Subject: FW: Y/105/19/PL and Y/106/19/L

Following our telephone conversation in April and previous email correspondence regarding the planning and listed building application for Stakers Farm Barns, we are intending to make the following amendments to the application to secure a positive determination:

Drawing Title
Proposed Plans - Barn 1

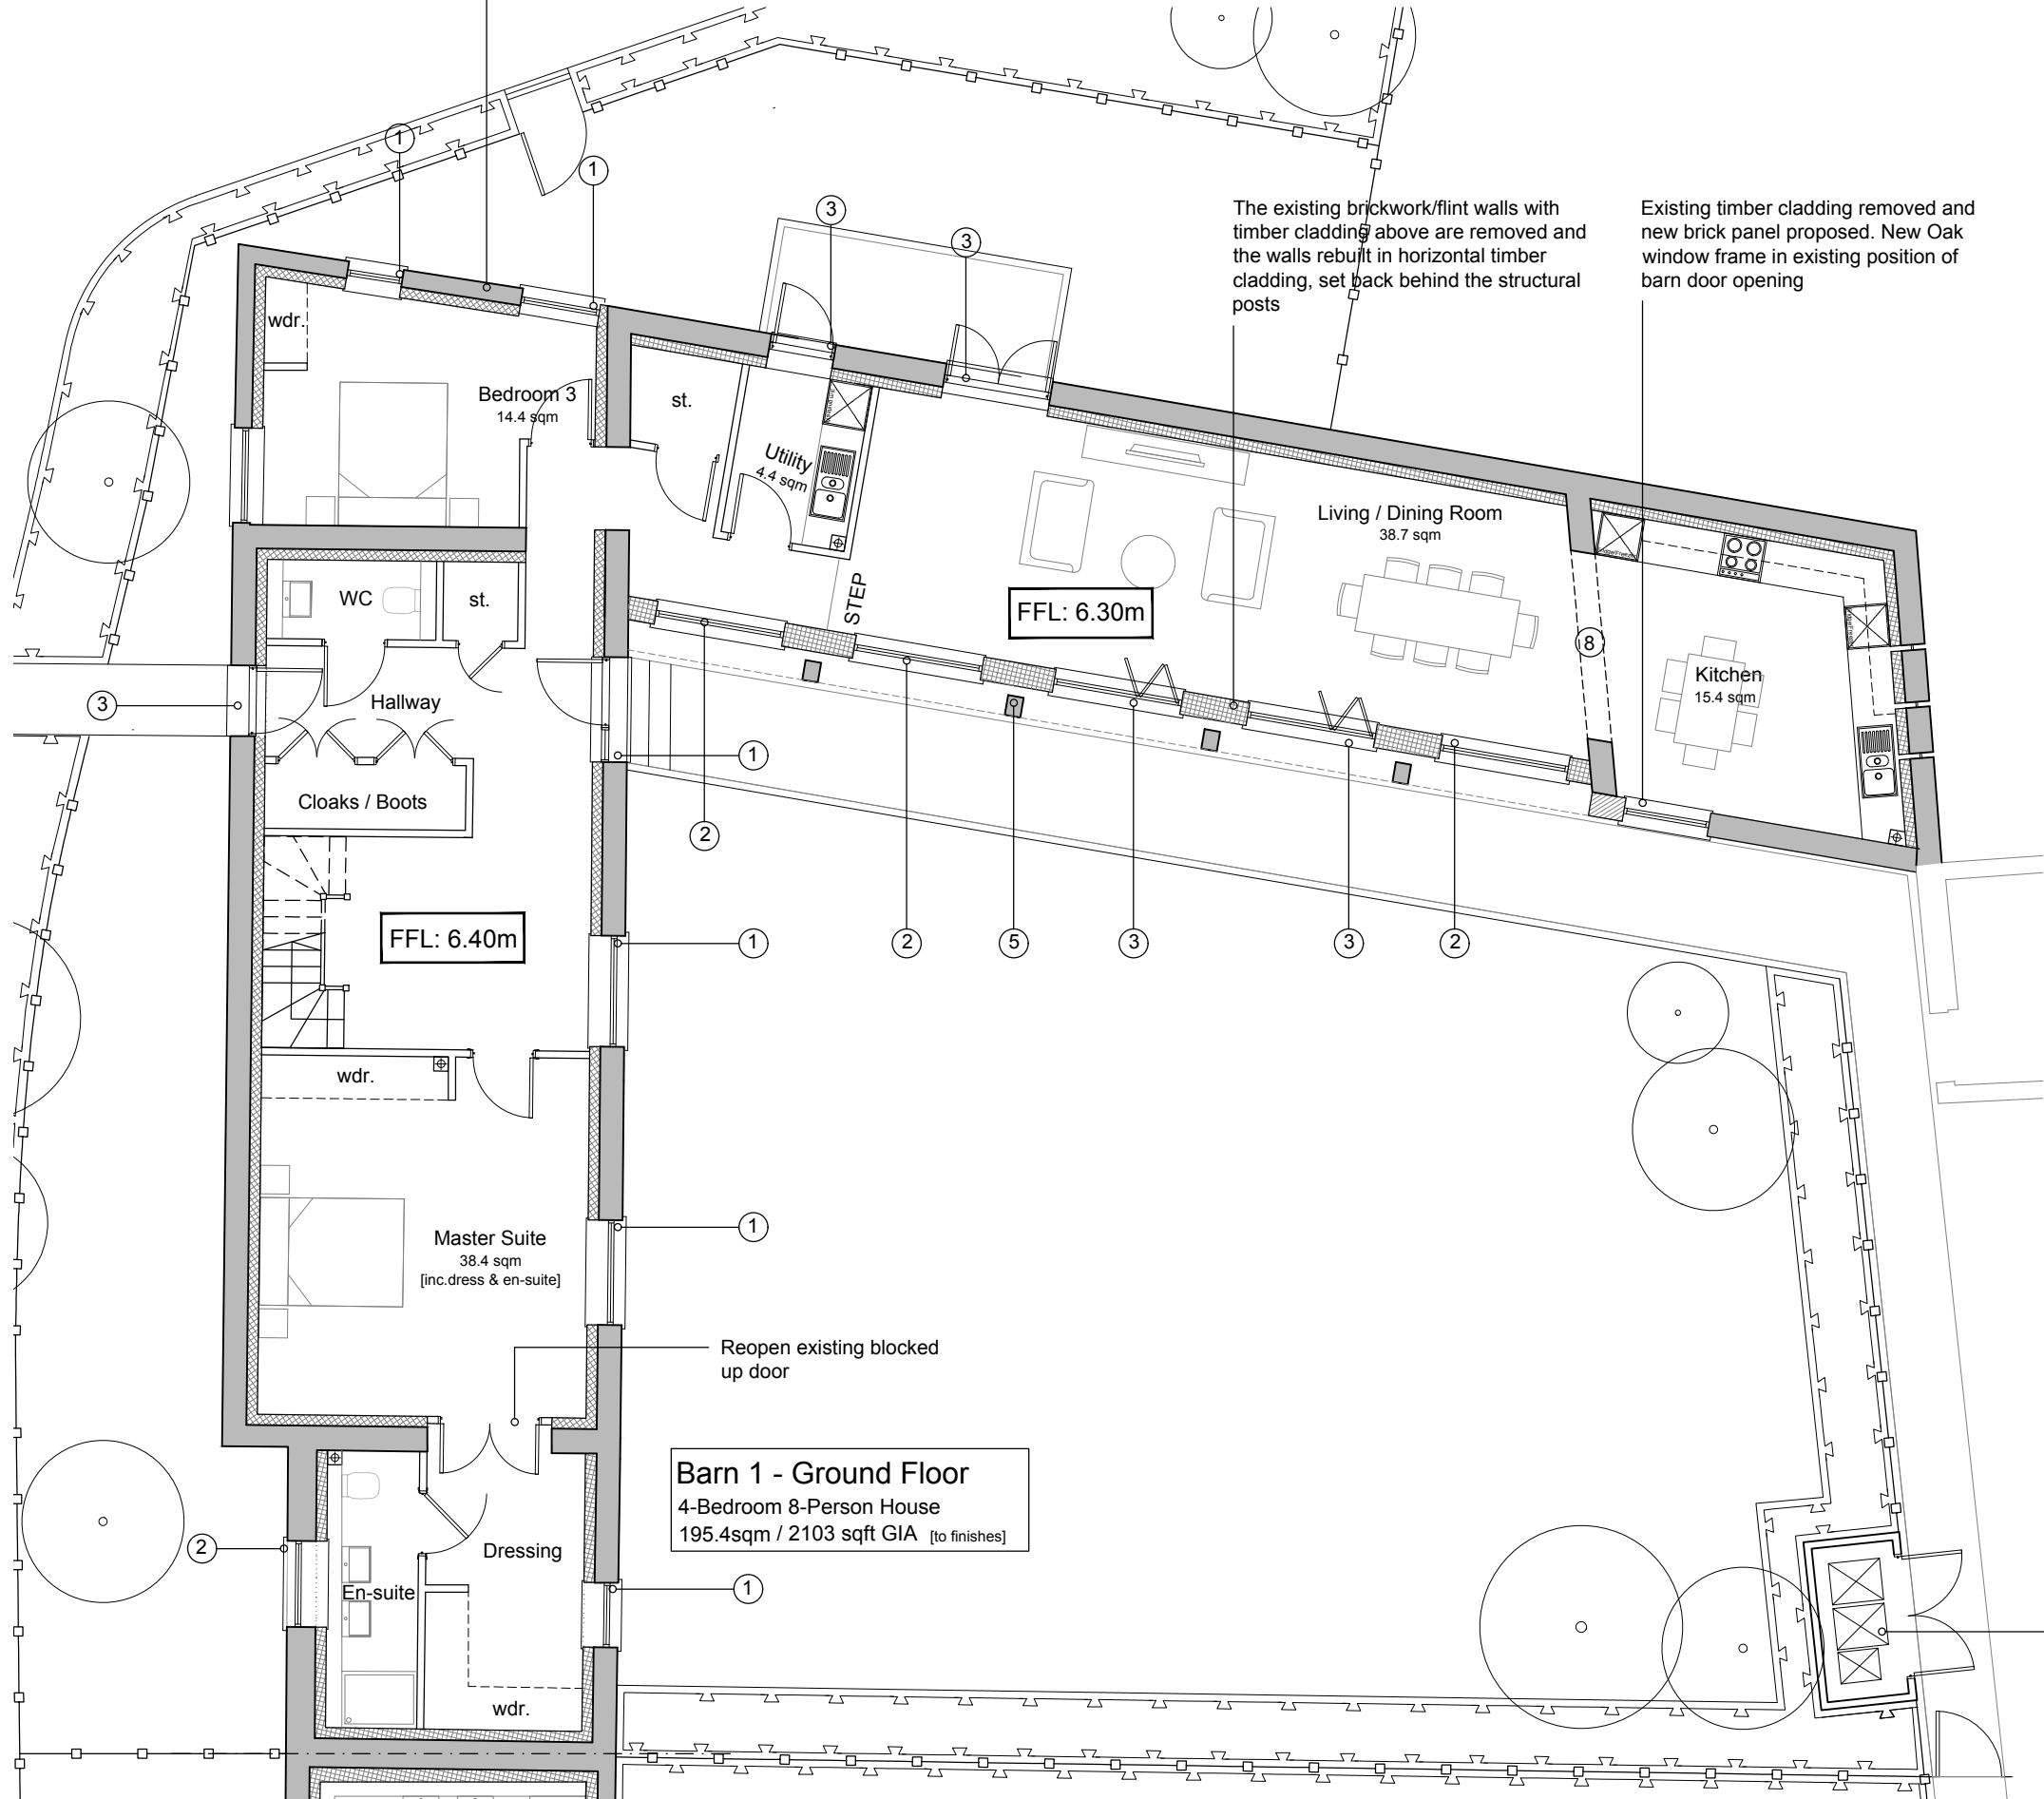
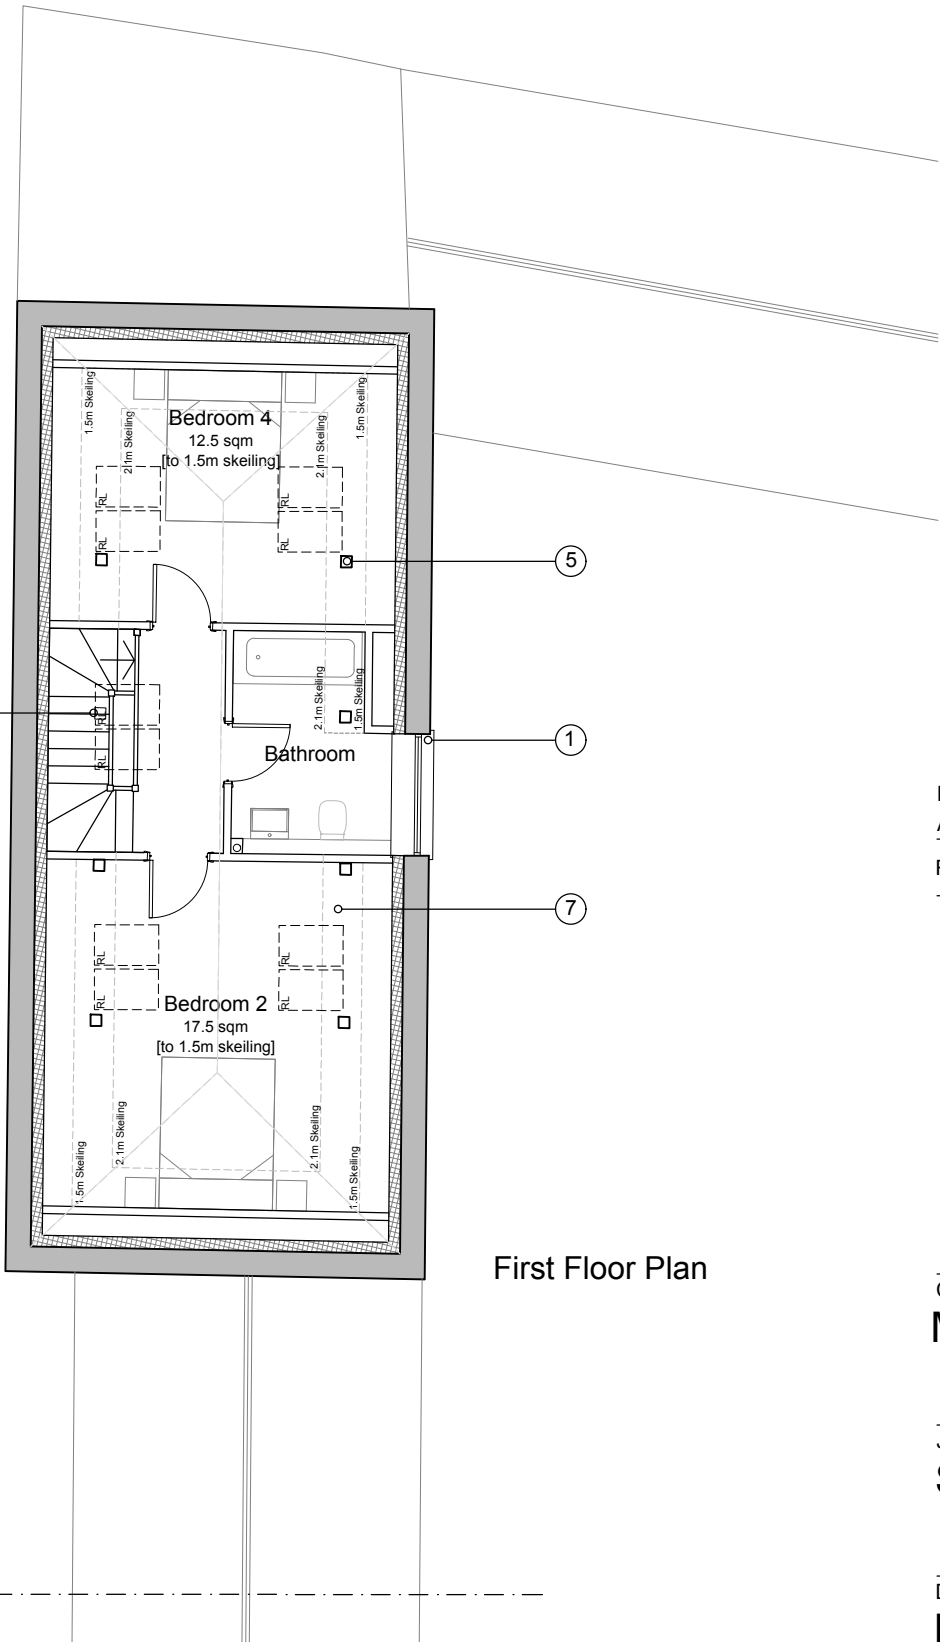
We will remove as many rooflights as possible from this barn. However, we cannot remove all the rooflights as we will need to provide light to the bedroom to make it a habitable space. A roof light will also be required to provide purge ventilation (Part F of Building Regs) otherwise a mechanical system would be needed. Under the Building Regulations we will also need to meet the Daylight and room brightness guidance set within British Standard BS 8206-2:2008 Lighting for Buildings. We will therefore seek to provide the very minimum amount of rooflights necessary to meet Building Regulations and seek to locate them on the least prominent part of the roof.

South elevation – we will amend the proposed alterations to the single storey element and reduce the amount of glazing, ensuring that this elevation is changed as little as possible from the existing situation.
